Yorkshire Green Energy Enablement (GREEN) Project

**Document 8.25.1 Applicant's Response to Examining Authority's
Second Written Questions (ExQ2)**

Planning Inspectorate Reference: EN020024

Title
NATIONAL GRID
(YORKSHIRE GREEN ENERGY
ENABLEMENT PROJECT)
ILLUSTRATIVE PLAN: ACCESS DURING
CONSTRUCTION PHASE - SHIPTON
REGULATION 5(2)(o)
SHEET 2 OF 2

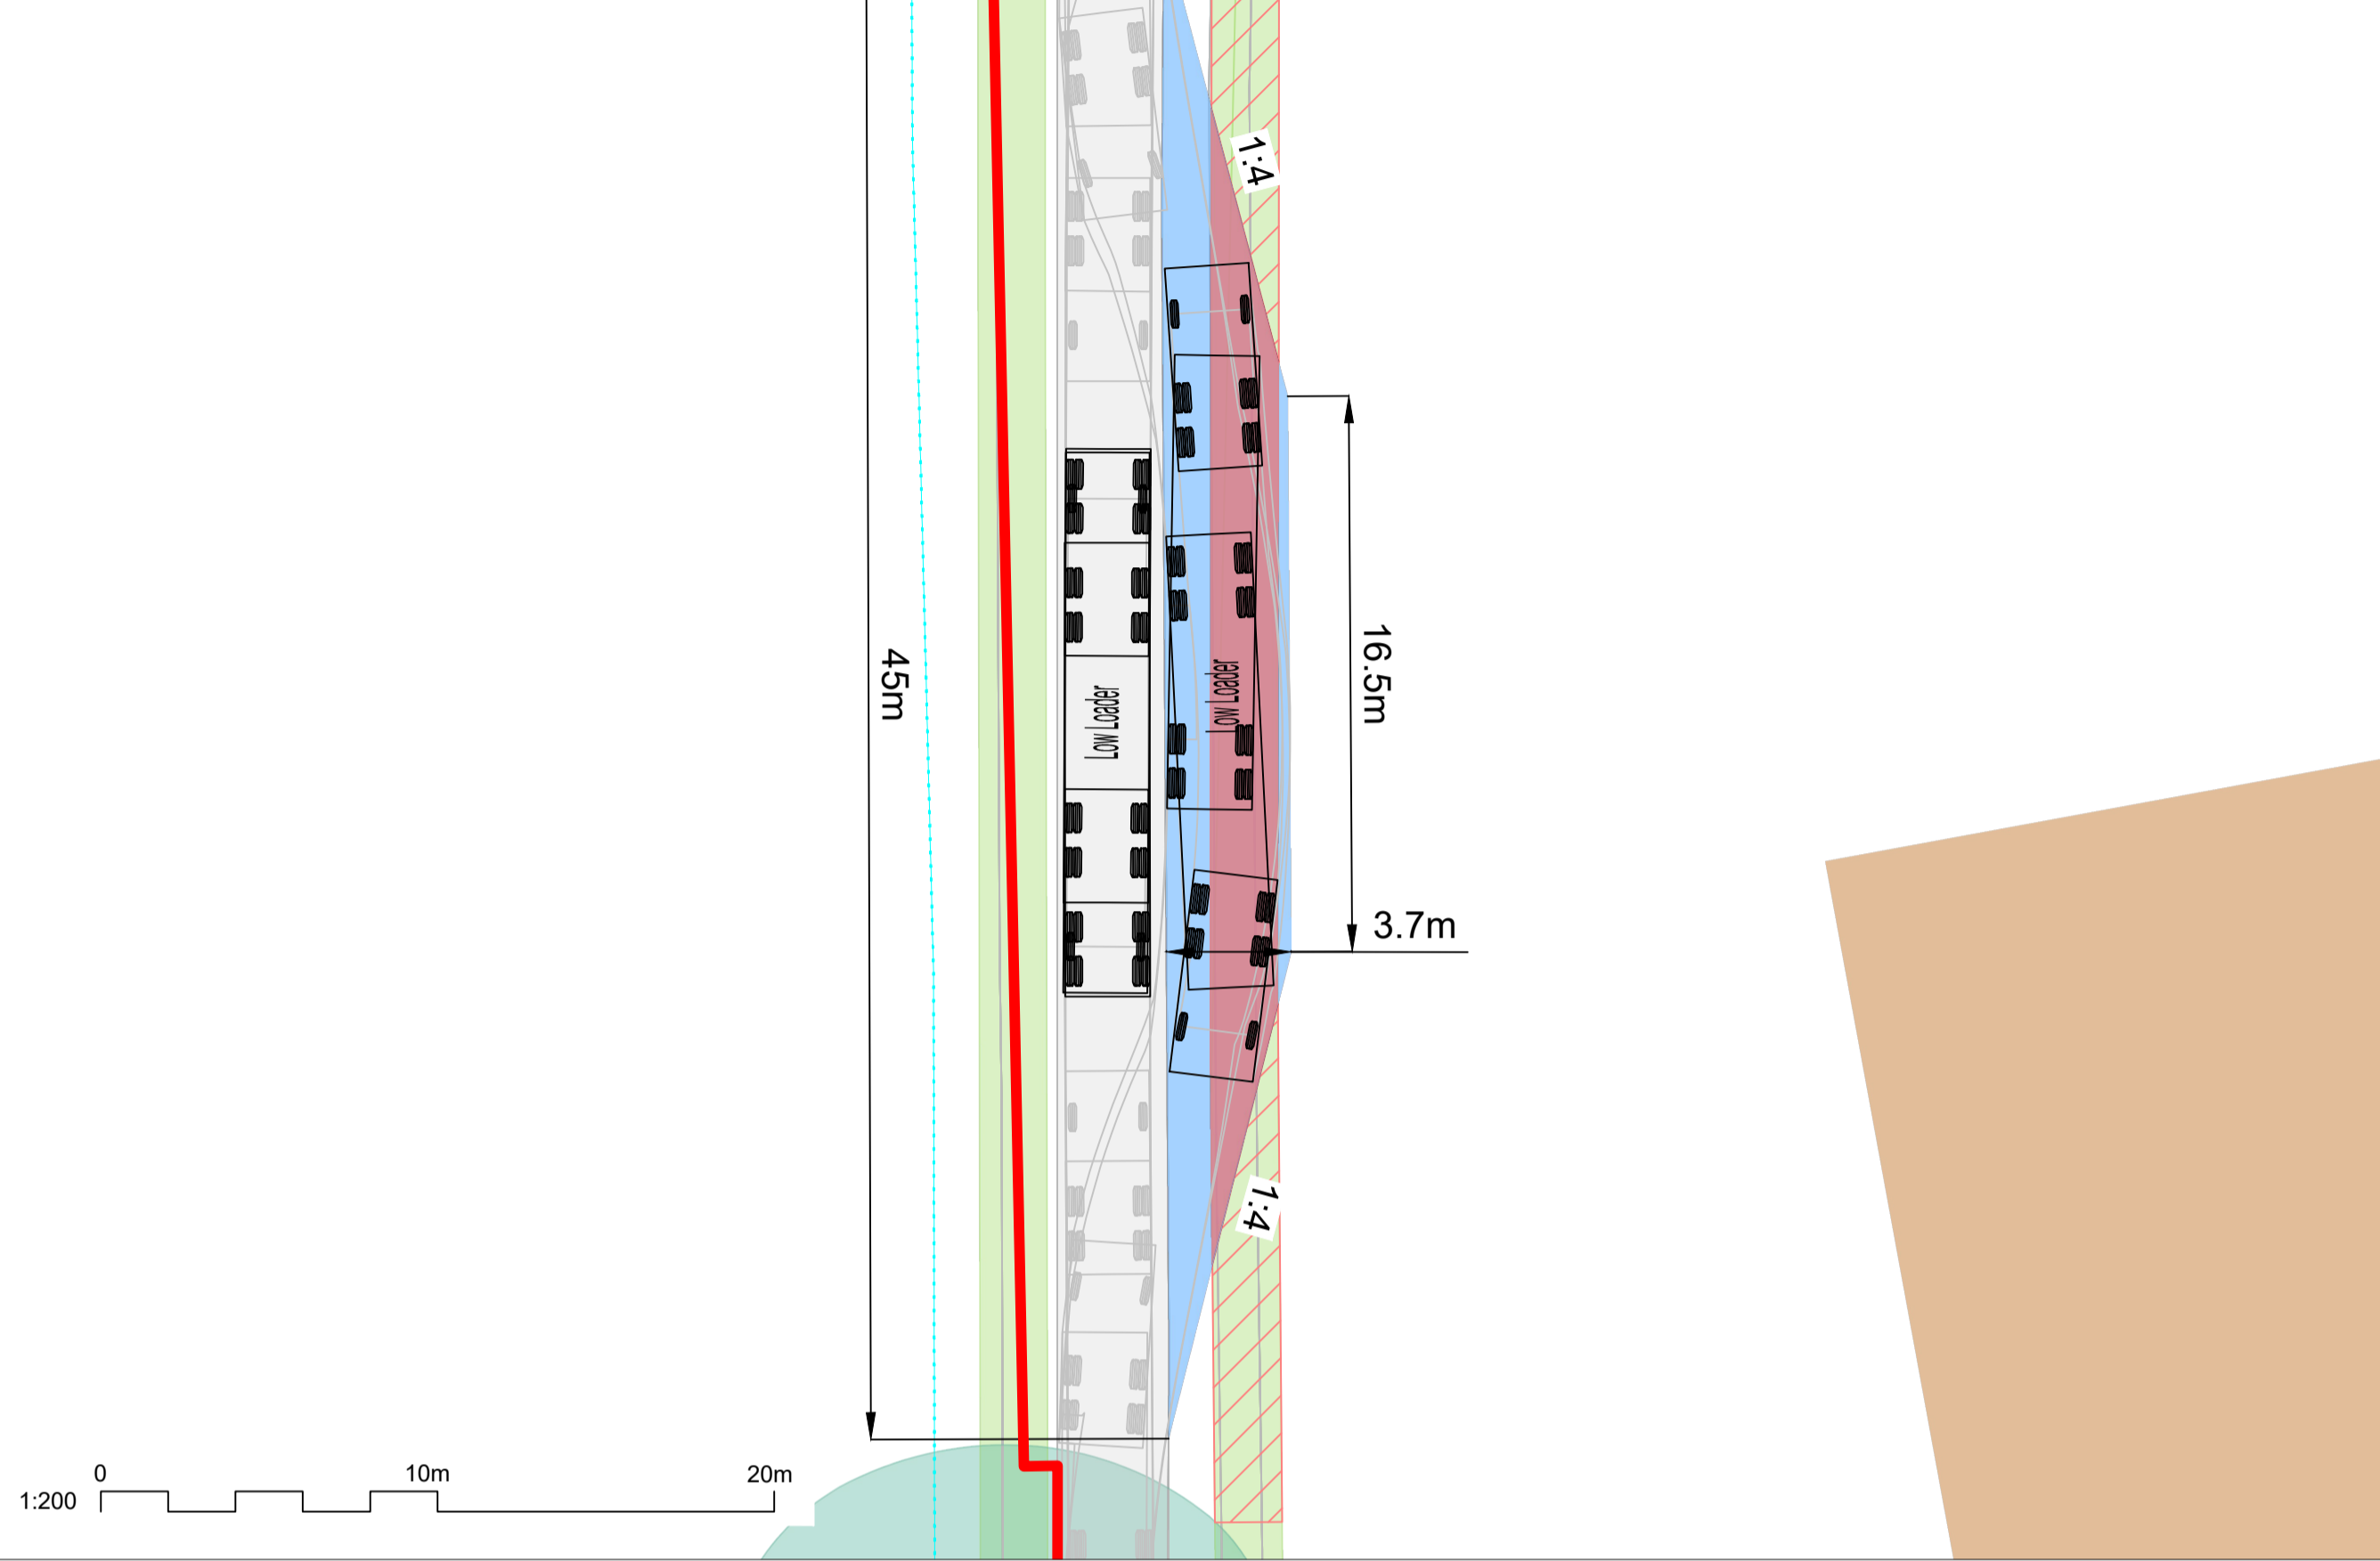
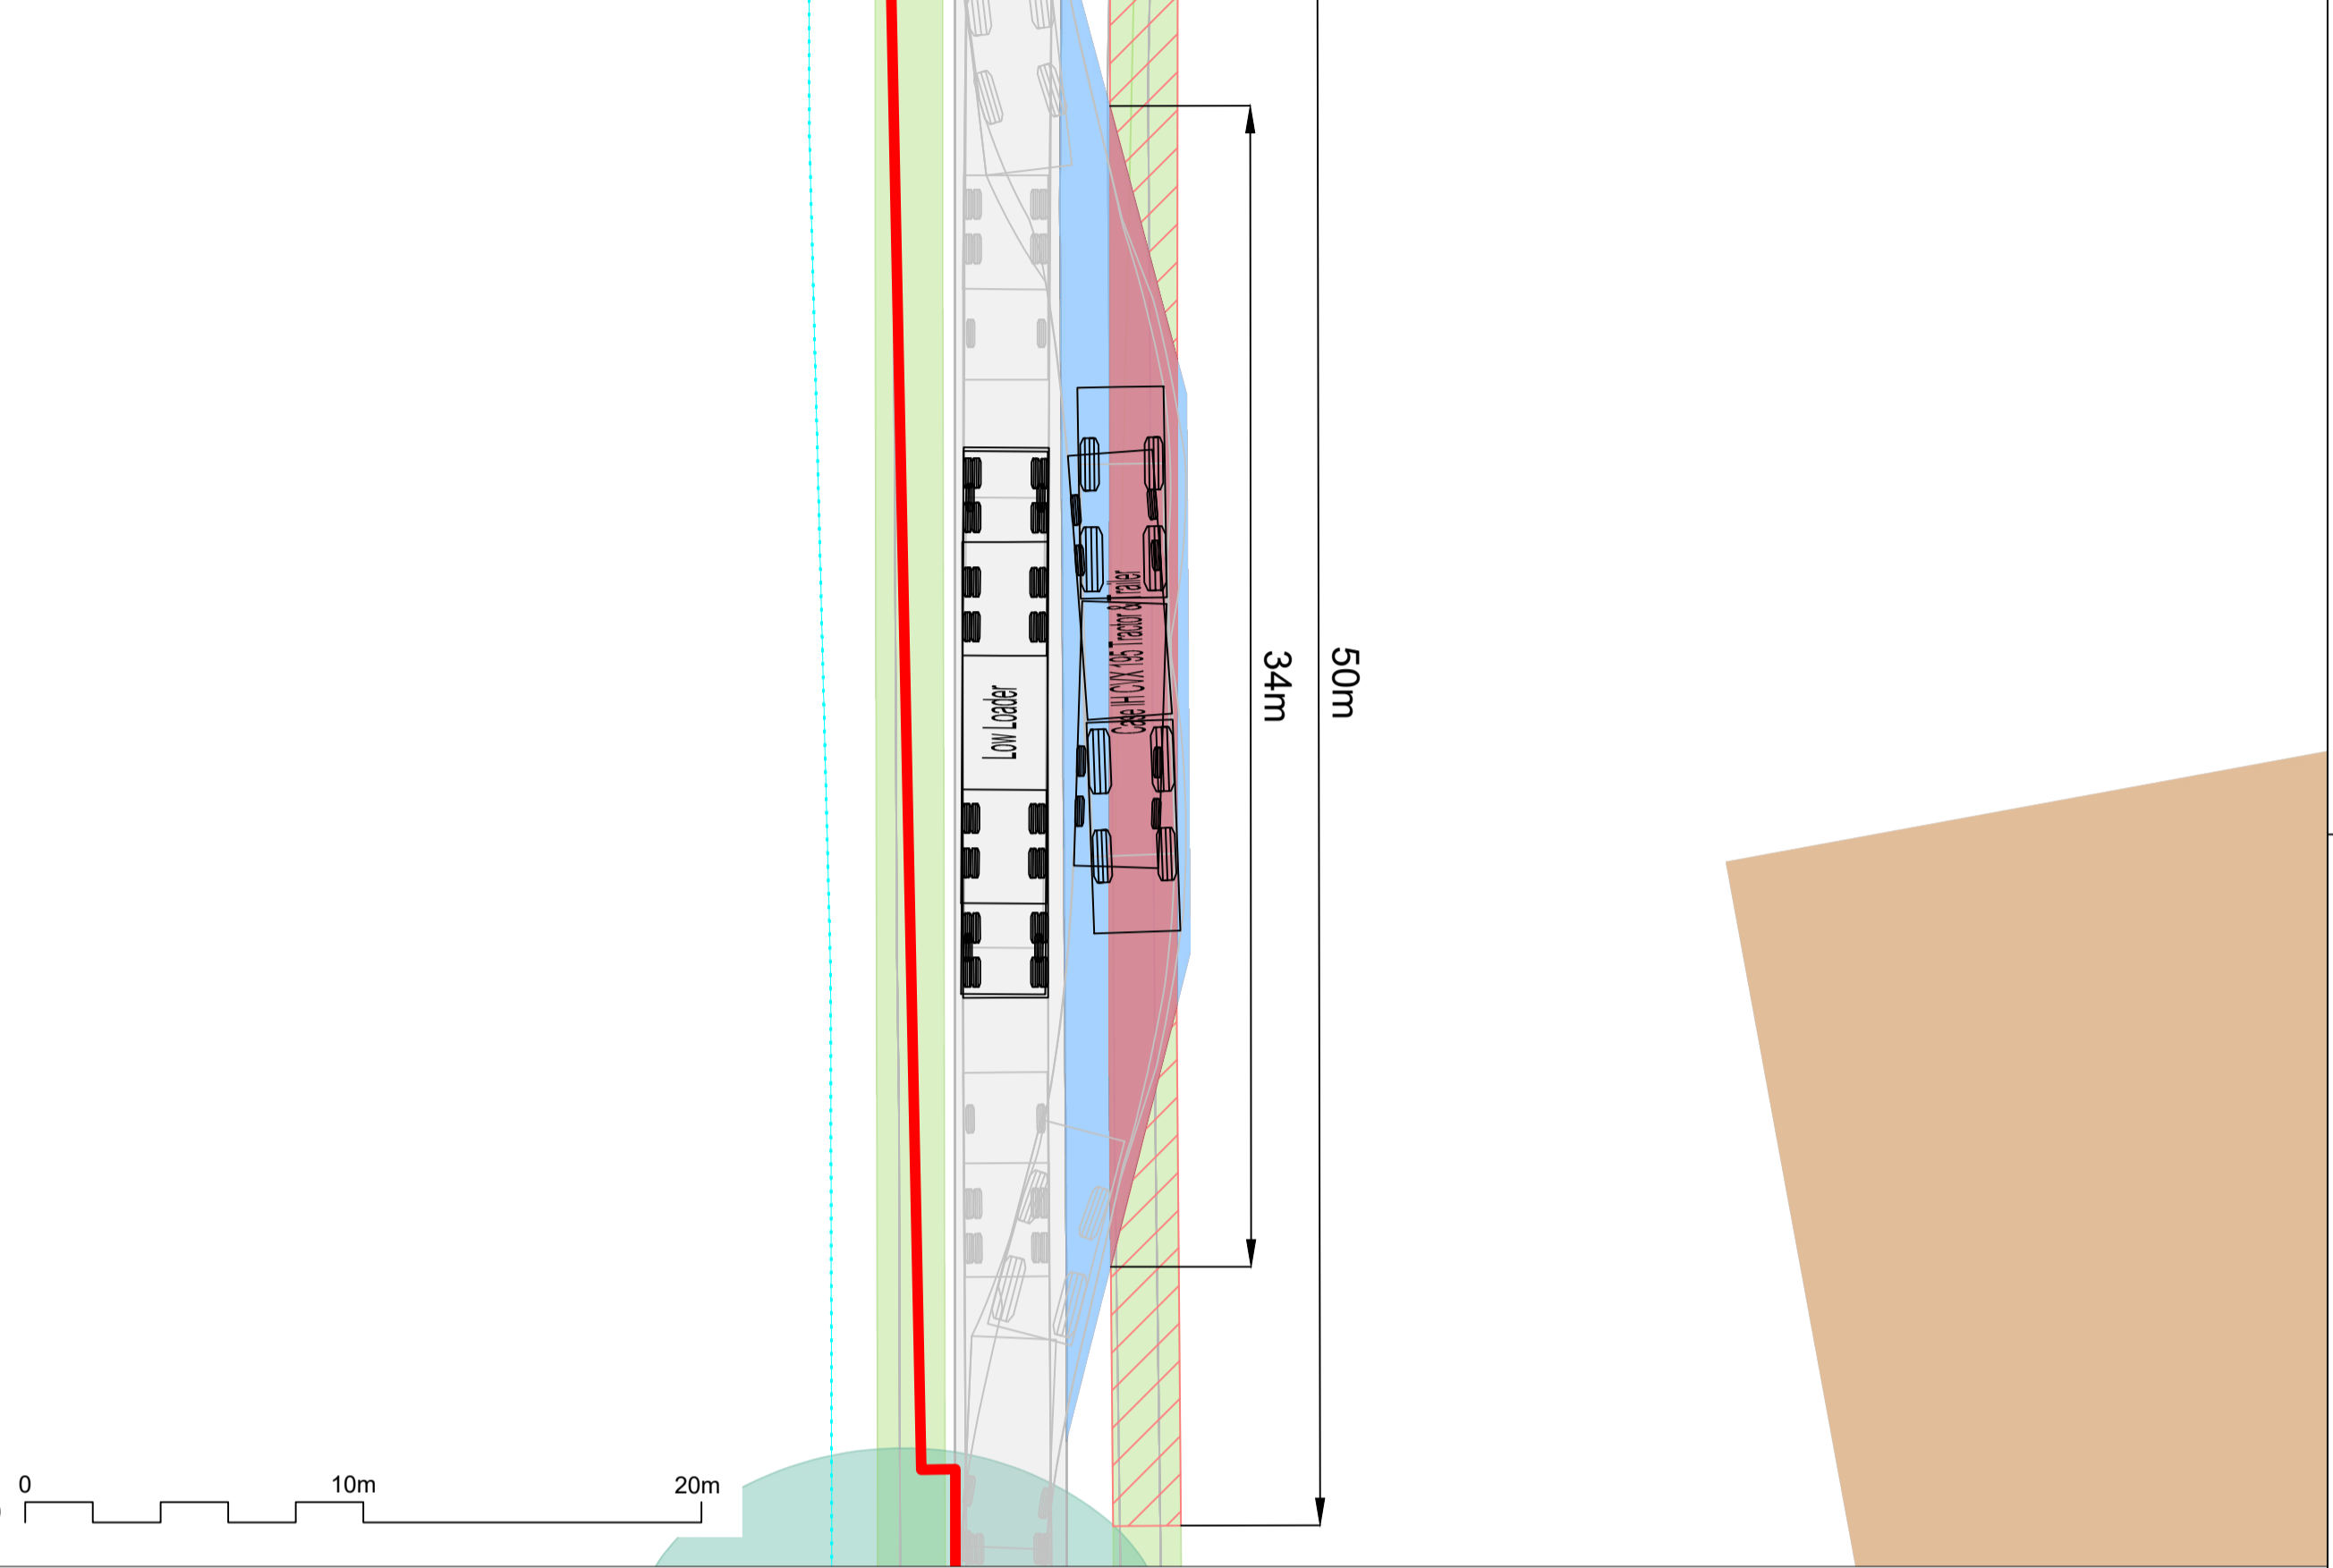
Ref No.	Respondent:	Question:
1.3	1.3 Post-hearing submissions	
Q1.3.1	The Applicant	<p>Illustrative Plan: SP005 Access During Construction Phase [REP4-026], Appendix D</p> <p>The ExA notes this is an illustrative plan, as requested.</p> <ol style="list-style-type: none"> a) Is this the sort of plan which would form part of the tree and hedgerow protection strategy (THPS) for approval by the relevant planning authority? b) If so, would there be clarity on the areas for hedgerows to be removed at the time of submission for approval? c) Has this illustrative plan taken account of the Northern Powergrid undergrounding works which would precede the traffic management works, if required? d) If not, what would the process be for seeking approval from the relevant planning authority for those pre-commencement works? <p>Applicant’s Response:</p> <ol style="list-style-type: none"> a) This type of plan would not form part of the THPS but is the type of detail that would inform the development of the THPS (as part of a suite of design information to allow tree loss or impacts to be finalised). The THPS would include an Arboricultural Method Statement, Tree Protection Plan (showing the final extent of tree loss/retention and position of fencing or ground protection), schedule of tree works (including pruning and removal) – e.g., an updated version of the schedule in Annex 3I.2 submitted with the Arboricultural Impact Assessment (Document 5.3.3I(B)), [REP4-009 to REP4-011]. This would take into account the final design and any other supporting information, such as that obtained from a site walkover, as required. b) The THPS would show the final extent of tree and hedgerow loss for each stage of the Project which would be the subject of approval under Requirement 9 of the DCO. If there was any change required during works following the approval of the THPS e.g. due to the flexibility in the limits of deviation, this would be discussed with the relevant LPA and consent would be obtained in advance of any additional tree works taking place, if required. This accords with the Biodiversity Mitigation Strategy (Document 5.3.3(D)) Appendix 3D [APP-097] which states in section 3.3. that <i>‘any deviations from the plan will be agreed in advance with the ECoW and relevant stakeholders (i.e. Local Planning Authority) where necessary, with advice from an appropriately experienced and qualified arboriculturist where required’</i>.

Ref No.	Respondent:	Question:
		<p>c) and d) The plan provided in Appendix D [REP4-026] assumes that any undergrounding of the Northern Powergrid lines has already been undertaken. The plan is only intended to show an illustrative view of what any bellmouth and passing places could look like, and if any hedge removal would be needed to facilitate the works.</p> <p>Should the utility works and diversions be undertaken as pre-commencement work under Requirement 1(i – diversion and laying of underground apparatus and utilities)) of the draft DCO (Document 3.1 (D)), no trees or hedges would be removed pre-commencement but could be coppiced or pruned if required. Requirement 5(3) of the draft DCO (Document 3.1 (D)) identifies that all pre commencement work must be carried out in accordance with the Construction Management Plans, including the Code of Construction Practice (CoCP) and the Biodiversity Mitigation Strategy (BMS) which are listed in Requirement 5 and therefore are secured in respect of pre commencement works. The BMS includes elements covering vegetation loss and reinstatement. In paragraph 3.3 it states that tree loss will be as per the Arboricultural Impact Assessment and Tree Removal and Protection Plan but notes that <i>‘any deviations from the plan will be agreed in advance with the ECoW and relevant stakeholders (i.e. Local Planning Authority) where necessary, with advice from an appropriately experienced and qualified arboriculturist where required’</i>.</p> <p>Tree and hedgerow removal is not anticipated pre-commencement, however in the unlikely event that tree loss was required, as per the BMS National Grid would be required to agree any deviations with the Local Planning Authority in advance.</p>
